From: Maria Tomalova
Sent: Friday, February 18, 2022 4:19 PM
To: Peter Cleveland [REDACTED]
Subject: RE: Stakers Farm

From: Peter Cleveland [REDACTED]
Sent: 18 February 2022 16:13
To: Maria Tomalova <Maria.Tomalova@arun.gov.uk>
[REDACTED]
Subject: RE: Stakers Farm

From: Maria Tomalova
Sent: 18 February 2022 15:58
To: Peter Cleveland [REDACTED]
Subject: FW: Stakers Farm

BARNs 1&2 PROPOSED SOUTH EAST ELEVATION
SHOWING SHUTTERS OPEN

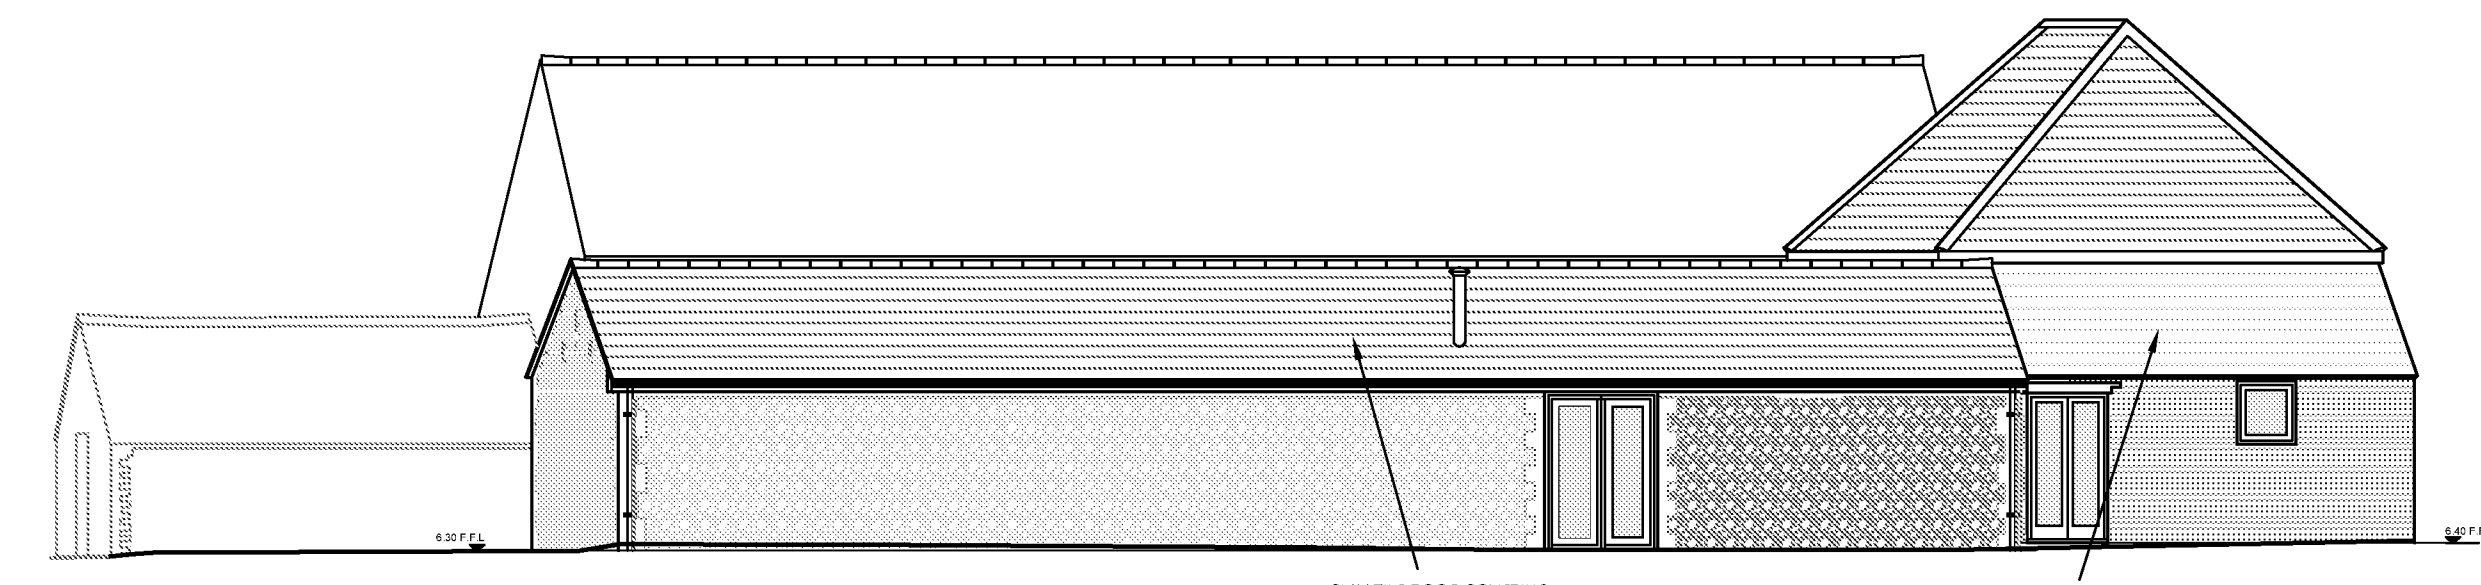
All the horizontal divisions should be back in the position where they were in approved plans and the same position should be maintain within all fenestration facing to the yard. The same apply for the largest opening. The replacement of the existing door (not original) as proposed is not acceptable and it would be helpful to discuss the replacement. There some other thing that should be clarified.

I do not understand, why they are showing bricks on this elevation to the right from the last opening; if you look at photo attached 1016 it shows flint.
